STATE OF NORTH CAROLINA  
DEPARTMENT OF TRANSPORTATION

August 31, 2020

Subject: **Revised Modification Request for Section 404 Individual Permit, Section 401 Water Quality Certification and Neuse Riparian Buffer Authorization** for Interstate 40 Widening and Improvements from I-440/US 64 (Exit 301) to just north of SR 1525 (Cornwallis Road), including improvements to NC 42 and SR 1010 (Cleveland Road) in Wake and Johnston Counties, Federal Aid Project No. IMNHF-040-4(139)301; TIP Numbers I-5111 and I-4739, Division 5. Debit \$570 from WBS Element 42346.3.1.

PROJECT REFERENCE NO.	SHEET NO.
1-5111/1-4739	42
R/W SHEET NO.	
ROADWAY DESIGN ENGINEER	HYDRAULICS ENGINEER
DOCUMENT NOT CONSIDERED FINAL UNLESS ALL SIGNATURES COMPLETED

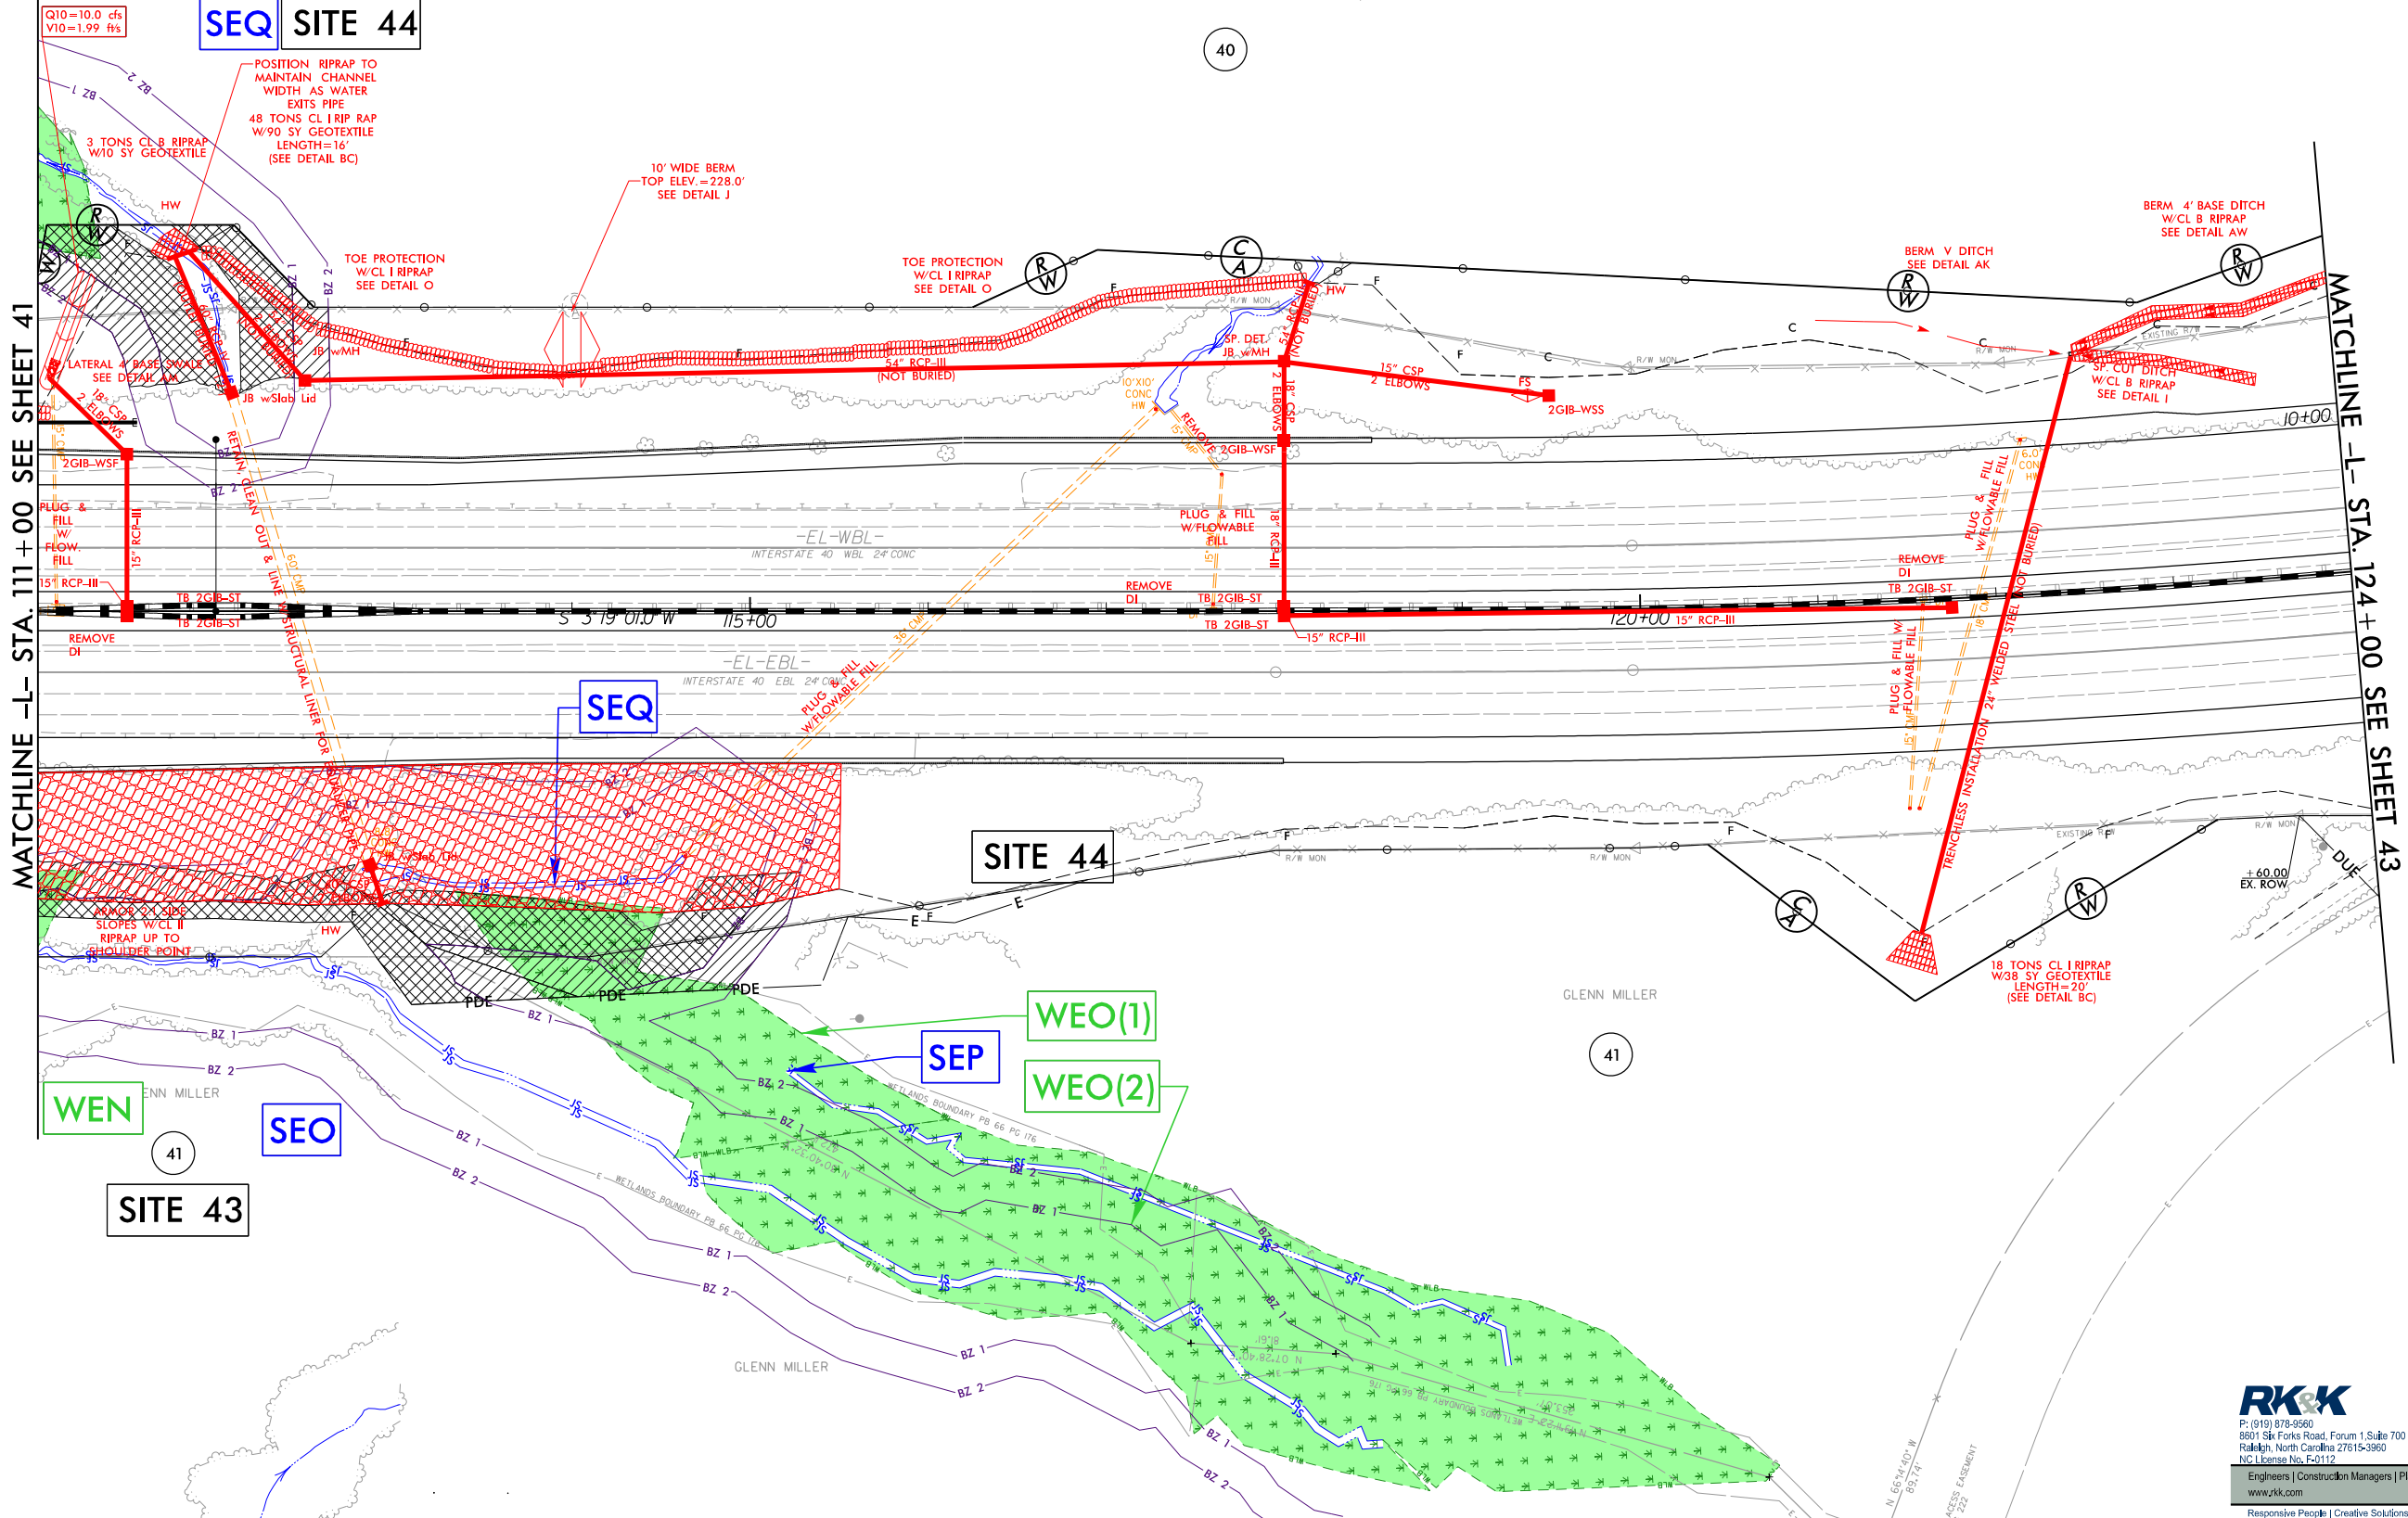
A field revision is being requested at Site 44. Currently, stream SEQ is piped from the east side of I-40 to the west side, travels along the west side of I-40 for approximately 80 feet, then is piped back to the east side. The original design kept this drainage pattern by boring a new 54" steel pipe to the west side of I-40 and then extending the existing 60" pipe to convey SEQ back to the east side. The new design proposes to install a 54" pipe along the east side of I-40 that outlets to the same 60" pipe, thus eliminating the need to bore a new 54" steel pipe. The 60" pipe will still be extended to convey any drainage from the west side to the east as well as to act as an equalization pipe. For construction sequencing, stream SEQ be placed in the relocation channel, as currently authorized, for approximately 3 months. However, this will be a temporary diversion and shown as temporary excavation in wetlands on Permit Drawing Sheet 124. Once the 54" pipe is installed along the east side of I-40, this channel will be backfilled to preexisting elevations, vegetated, and restored as a wetland.

- 0.043 ac of permanent wetland excavation becoming temporary
- +765 ft<sup>2</sup> of impacts to Buffer Zone 2 through abandoning the channel
